Our Case Number: ACP-322958-25

Re: Athlone link road phase 2. Proposed link road, joining the Crescent Junction (R915) to Southern Station Road Junction
Athlone, County Westmeath

Observation on a Strategic Infrastructure Development Application

Athlone link road phase 2. Proposed link road, joining the Crescent Junction (R915) to Southern Station Road Junction

Drawing file: Drawings / 120278-725 PL2 Typical Cross Section.pdf

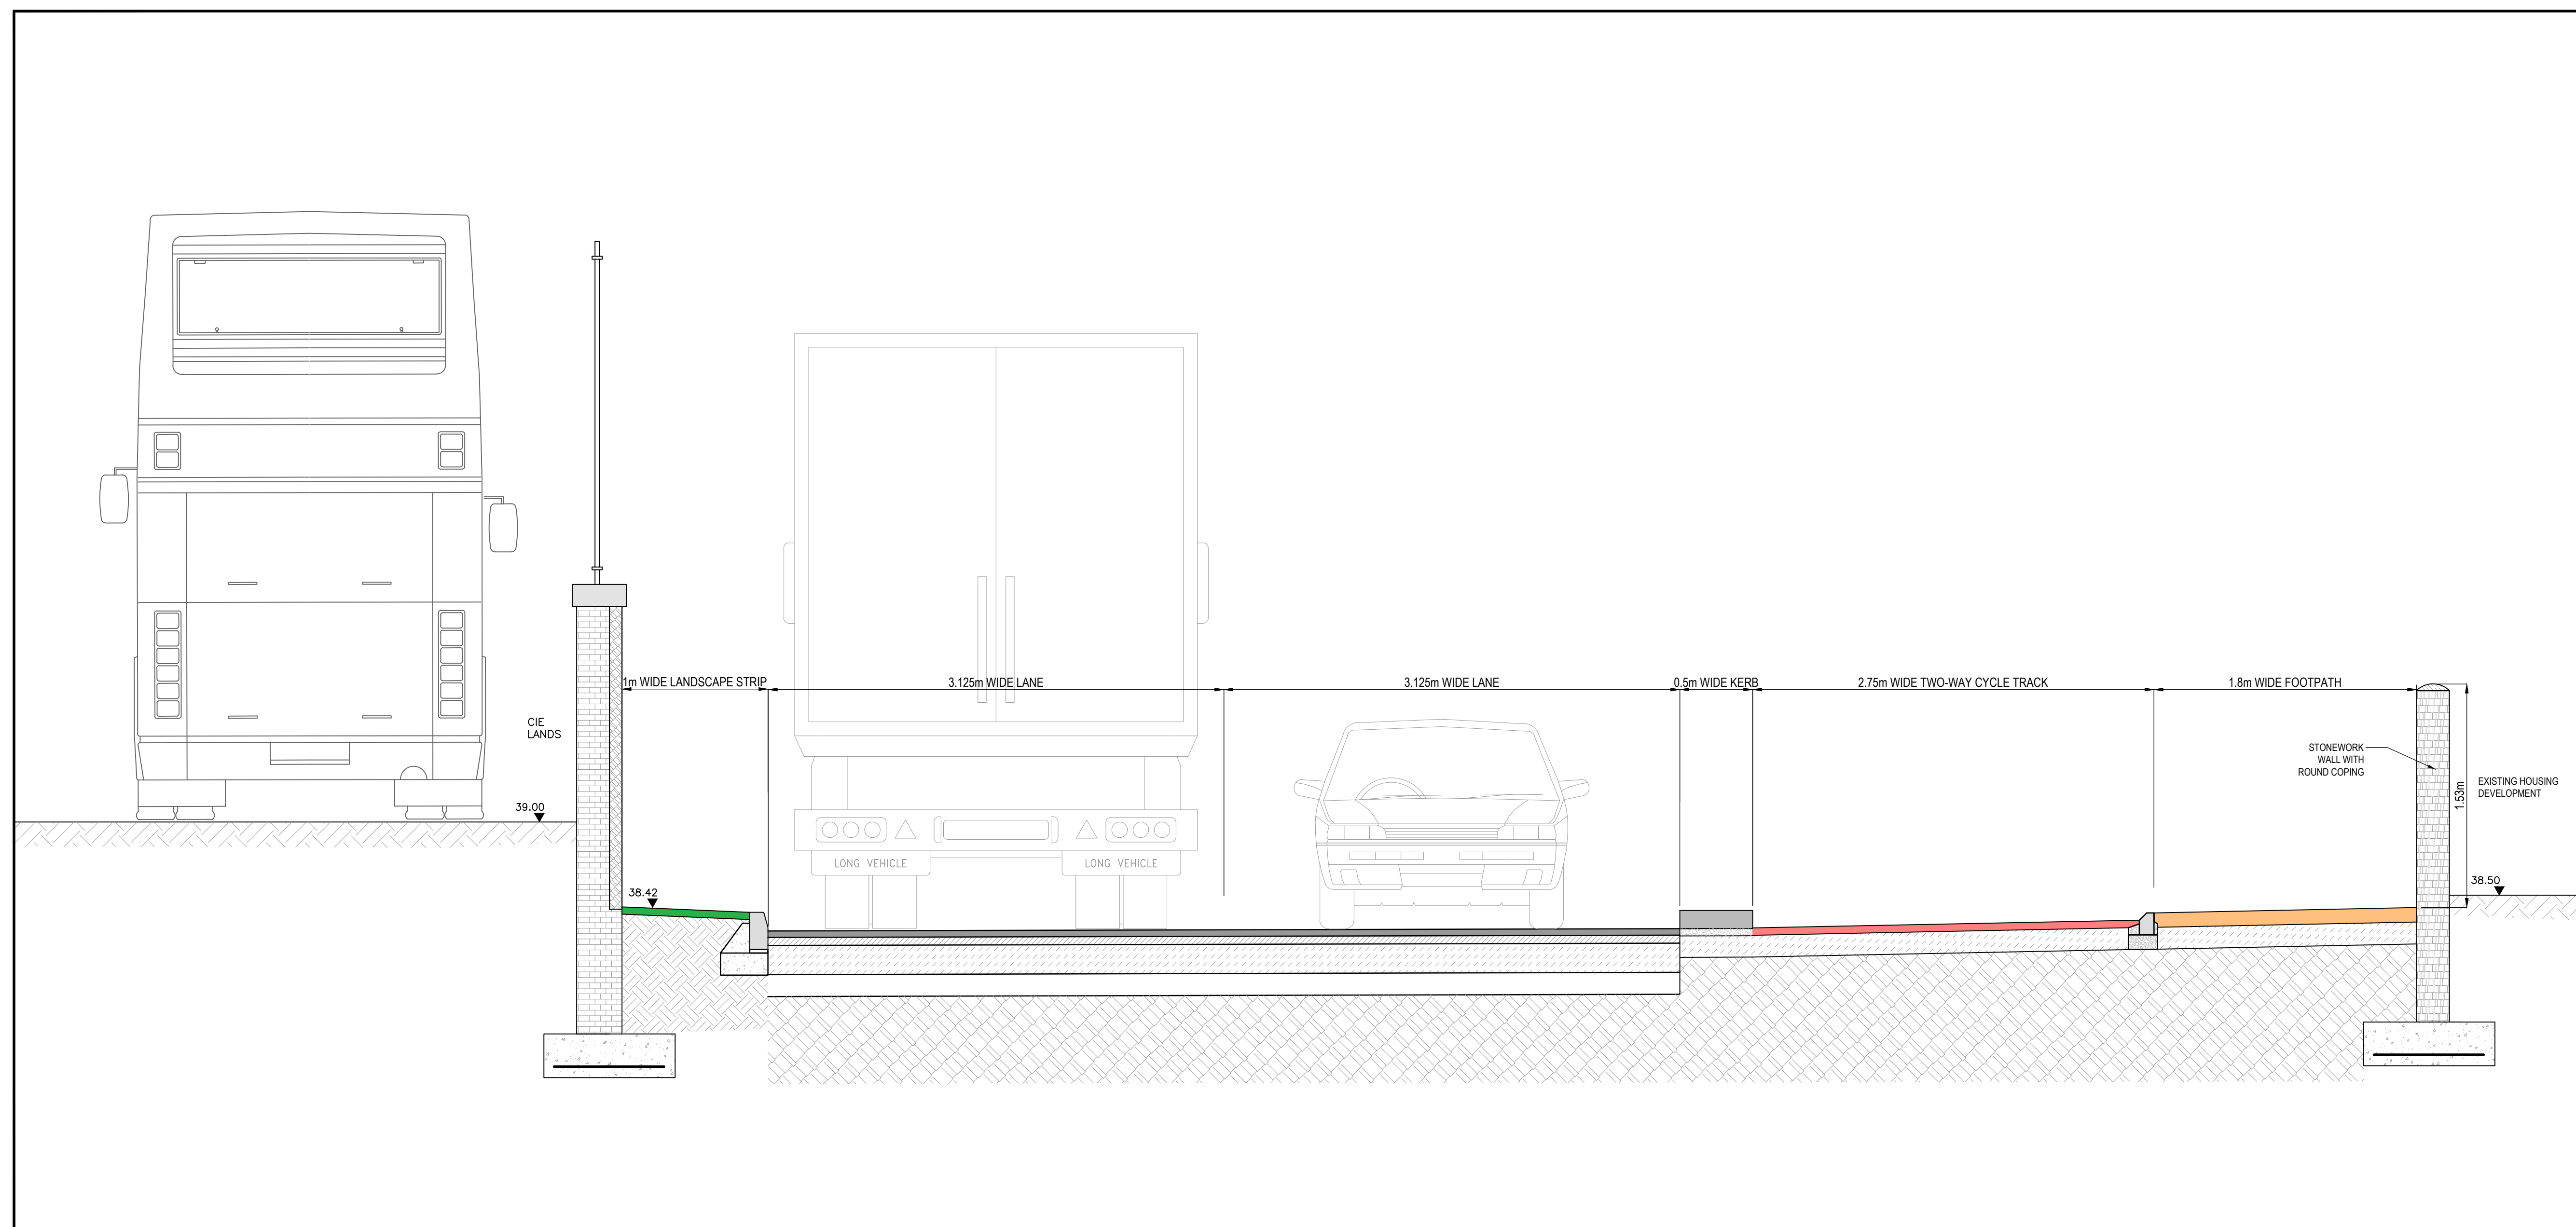
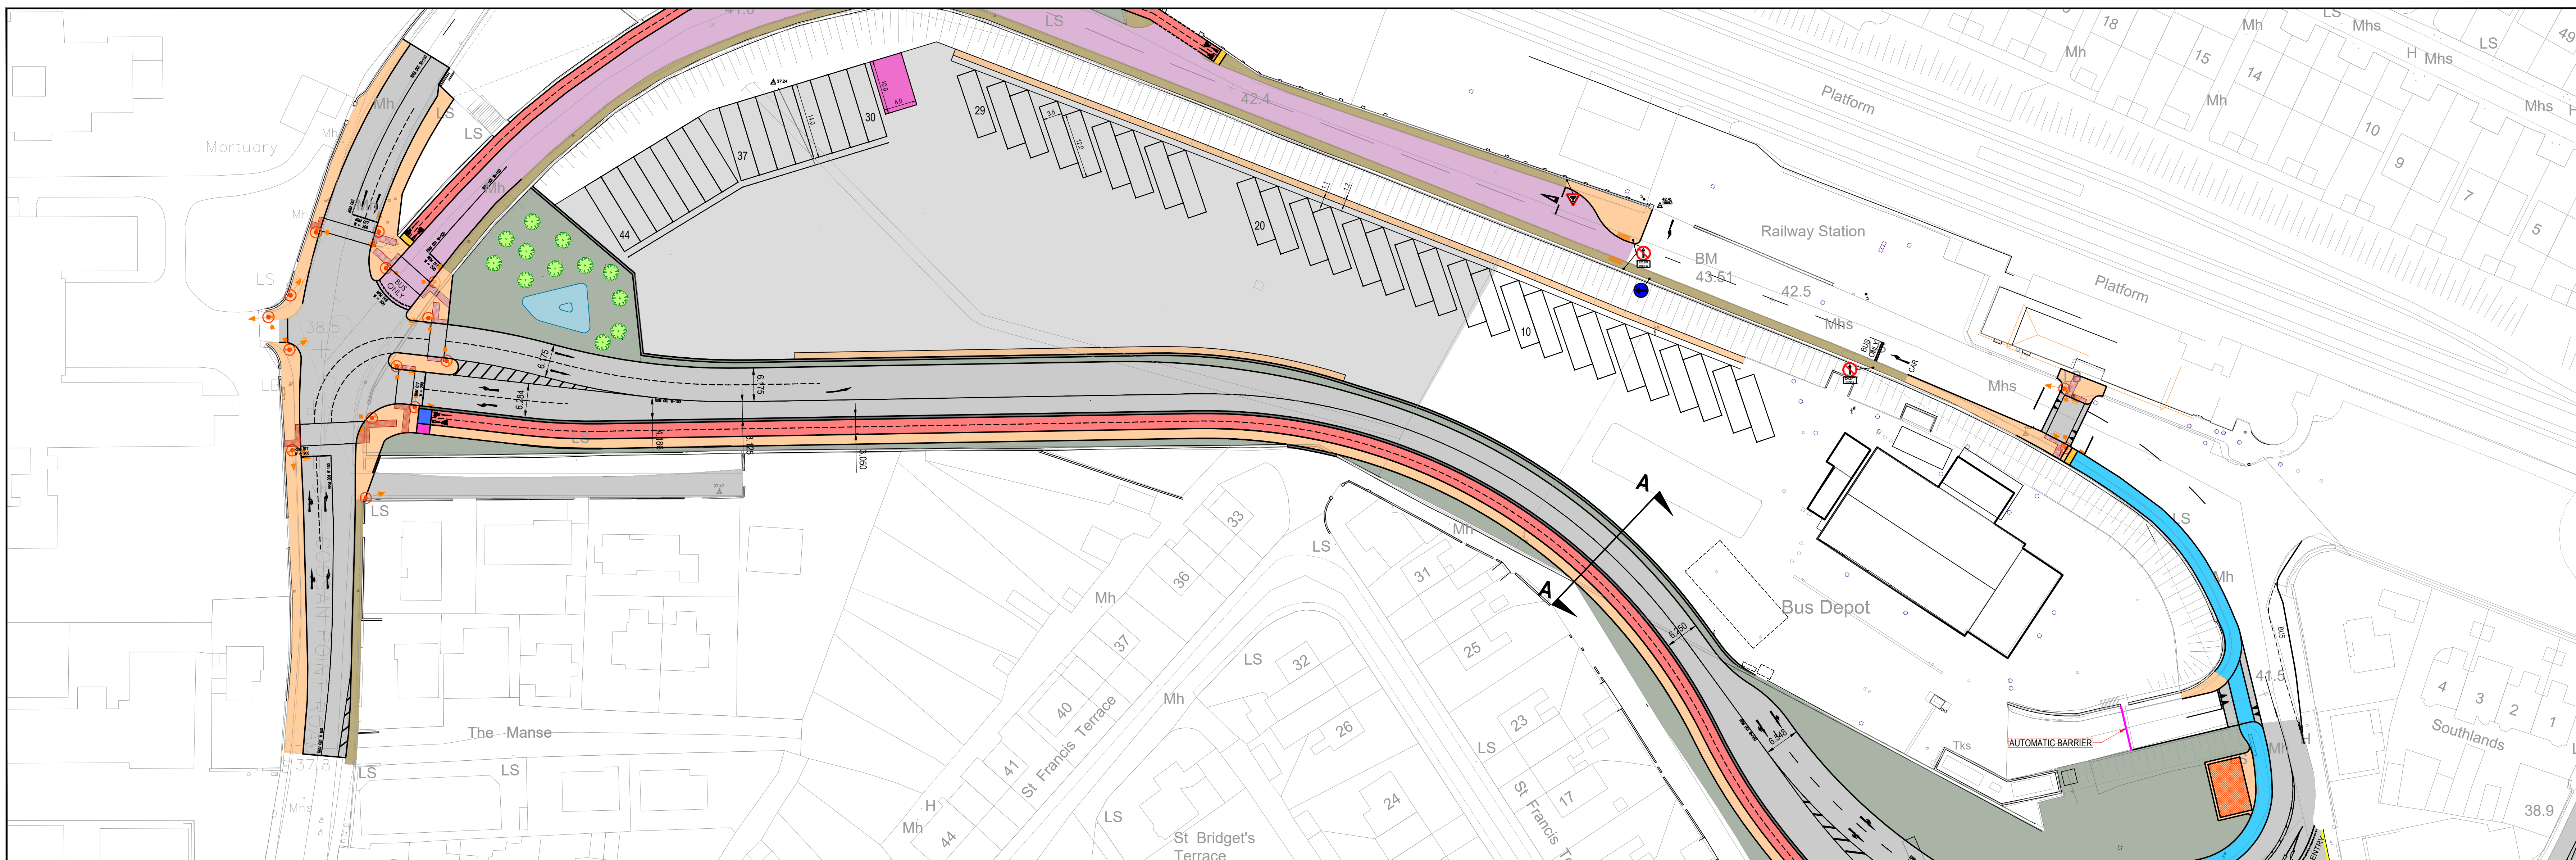
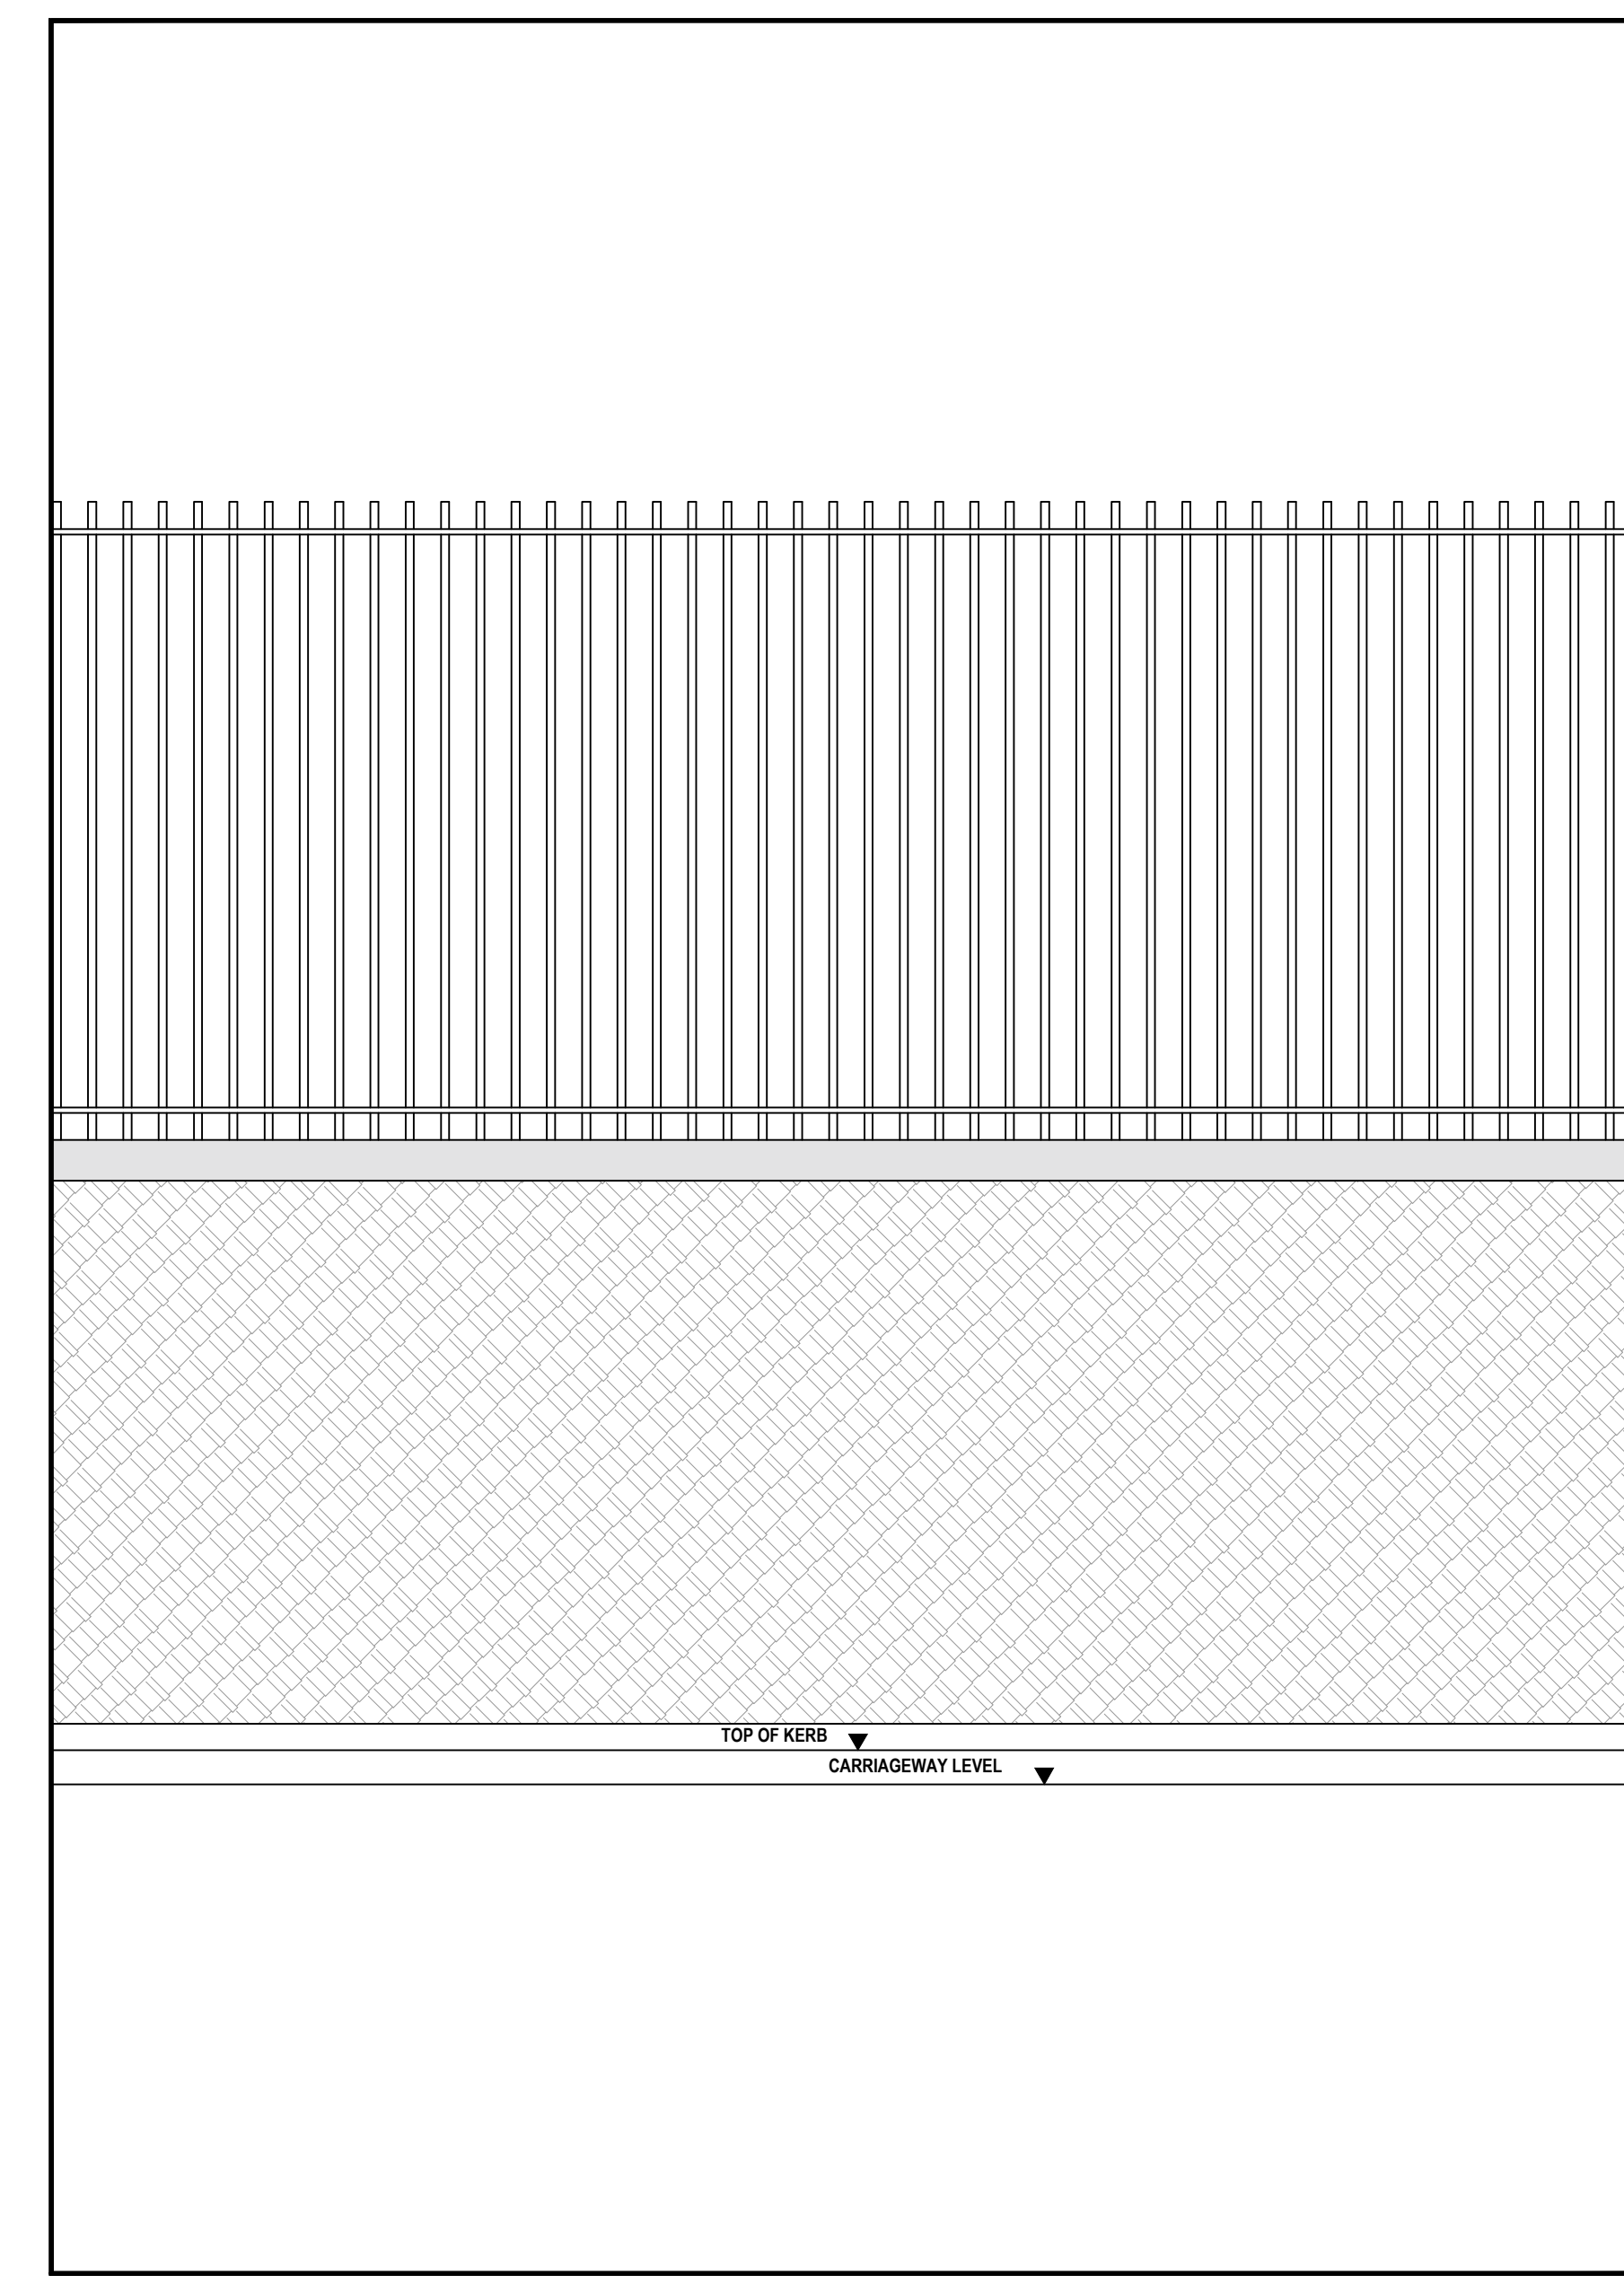
The link road's design prioritised private car use, creating a pedestrian-hostile environment with limited surveillance and lighting, contrary to guidelines in DMURS and national cycling manuals.

The cross section of the road as outlined in *Pl2_Typical_Cross_Section* is similar to Figure 2.13 on page 22 of DMURS which illustrates an example of a street that is hostile to pedestrians and cyclists (especially after dark). See below:

Proposed Cross section above.
